From: Clerk [REDACTED]
Sent: 20 January 2020 10:18
To: Planning.Responses <Planning.Responses@arun.gov.uk>
Subject: RE: Planning Consultation on: BN/128/19/OUT

APPLICATION NO: BN/128/19/OUT

Site Address: Land Adjacent to Highfield House Yapton Road Barnham PO22 0AZ

Description of Works: Application for Outline Planning Permission for development of 70 bed Care Home and 14 Assisted Living Bungalows with associated car parking, landscaping and access - Departure from the Development Plan

DATE  
JULY 2019  
JOB / DRWG No  
1693 / SP1

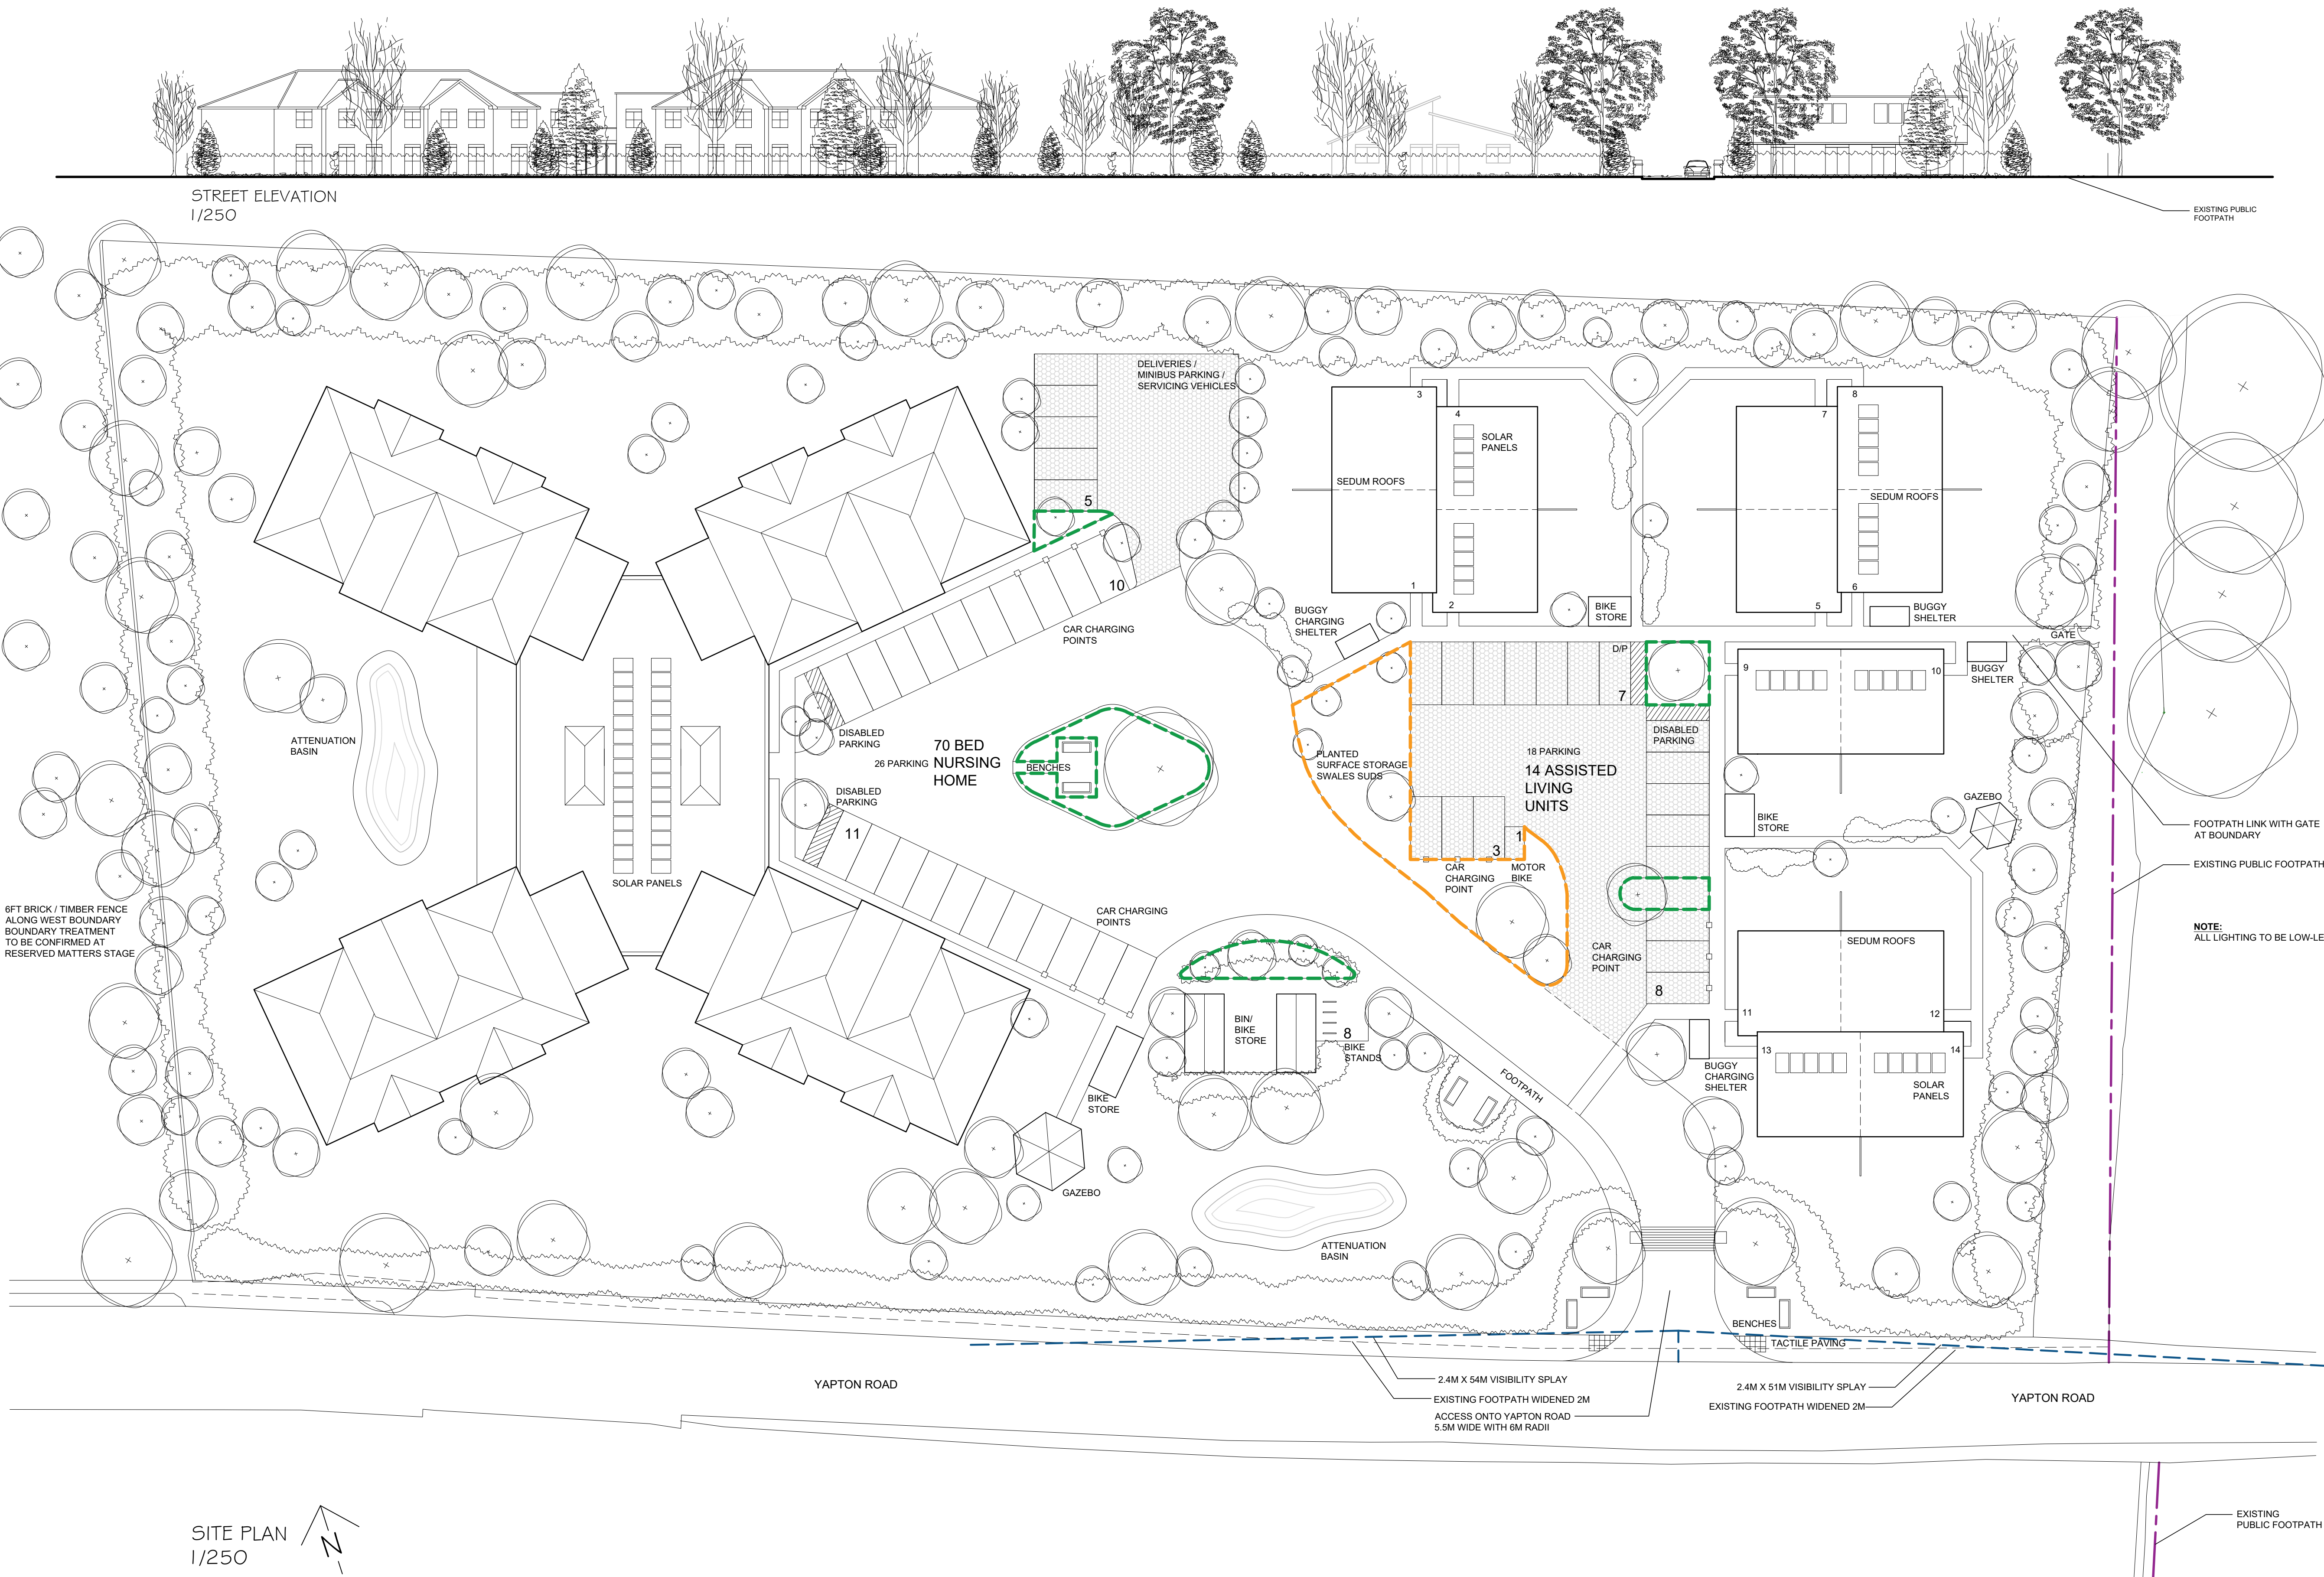
The need to light the site would have a detrimental impact on surrounding properties who currently have no street lighting and potentially on wildlife behaviour and habitats. The site is too far from local amenities for the type of residents that would be accommodated (the latest draft Design Guide states that residential property should not be more than 15 minutes from central village facilities). The need for such a facility has not been proved and contradicts ADC policy HMD2 because it is not in a built up area and as already stated is not close to local amenities (Windmill Shopping does not have the appropriate useful shops as stated) and the bus service only runs during the day six days a week at 2 hourly intervals.

Despite this parish council's strong objection on policy grounds should ADC be minded to approve the application the Council would wish to see mitigation measures included as enforceable conditions on the developer. These would include funding the widening of the footpath as far as feasibly possible in the vicinity of the application; and to also provide financial support for community facilities in the area in addition to CIL payments.
